RE: **Hope Plaza Subdivision (Lots 1 -6)**

File: **C20-D064**

Grading & Drainage Plan for Preliminary Plat, Work Order and Building Permit

PE Stamp: **4-21-2014**

GRADING & DRAINAGE PLAN

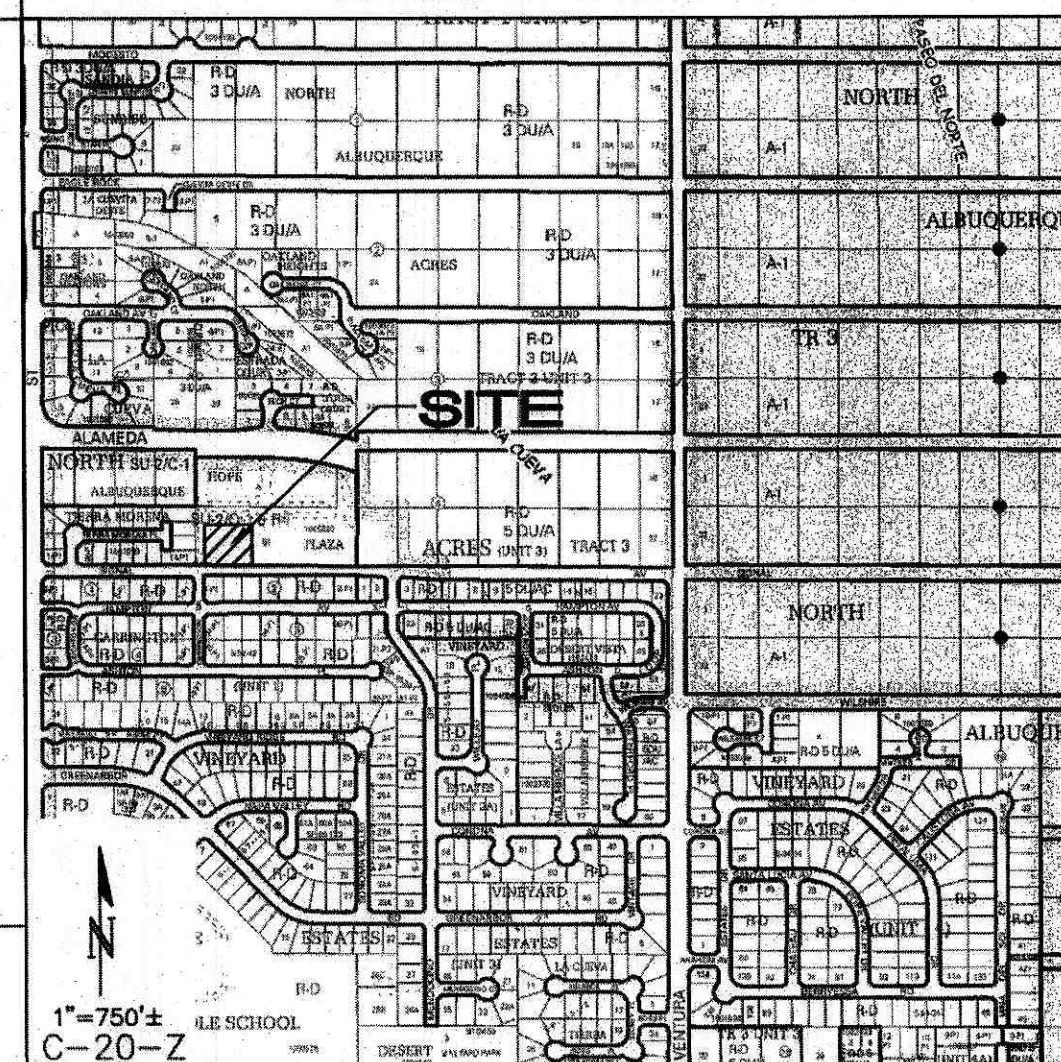
2. Retaining wall grades at the SE corner of Lot 5 show a 3-foot grade differential, but the associated Key Note 6 says 30" maximum retaining wall height.

3. Provide documentation of consent from the owners of Tract B-1-A to the offsite grading and construction on that tract.
4. Provide more detail of the 6' sidewalk along the east side of the site, including erosion and sediment control in the southern portion where adjacent dirt grades are roughly a foot above the sidewalk grades.

5. What is the size of the offsite basin that will discharge through the sidewalk culvert to Signal Ave., and is the culvert sized for the 100-year flow?

6. Prior to enforcement of the revised Drainage Ordinance next month, Hydrology is encouraging water harvesting measures to be voluntarily incorporated into site grading and landscaping. Can some flattened areas around the building pads be included in this plan to "harvest" minor storm flows?

SECTION C-C

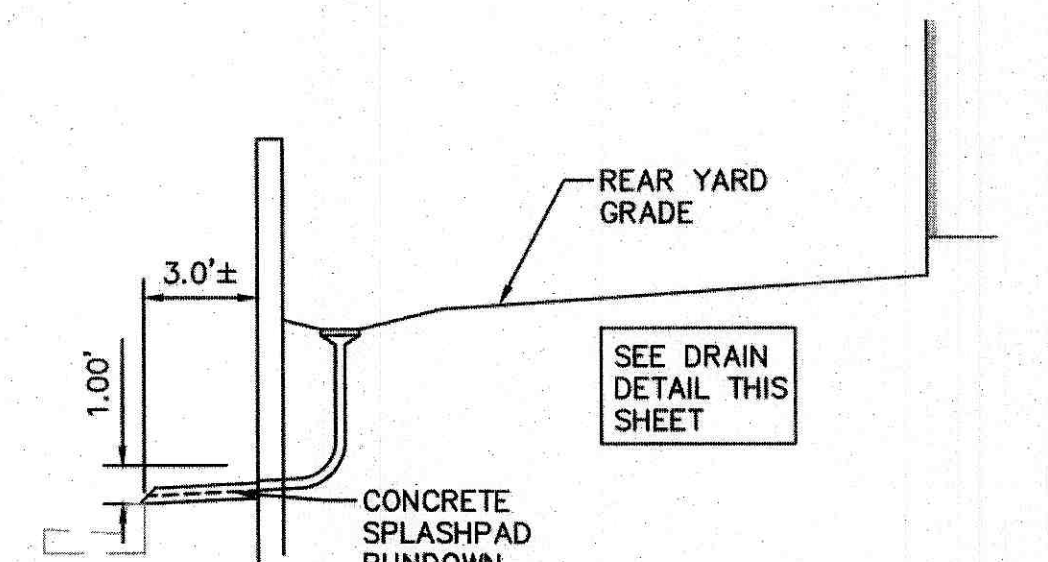
1. Section C-C cut on the west side of the lots does not match the actual conditions. Provide a new section applicable to that location, with sufficient detail to show how the U-channels will work with the 2.5' to 3.5' drop from the turned blocks to the existing street grades.
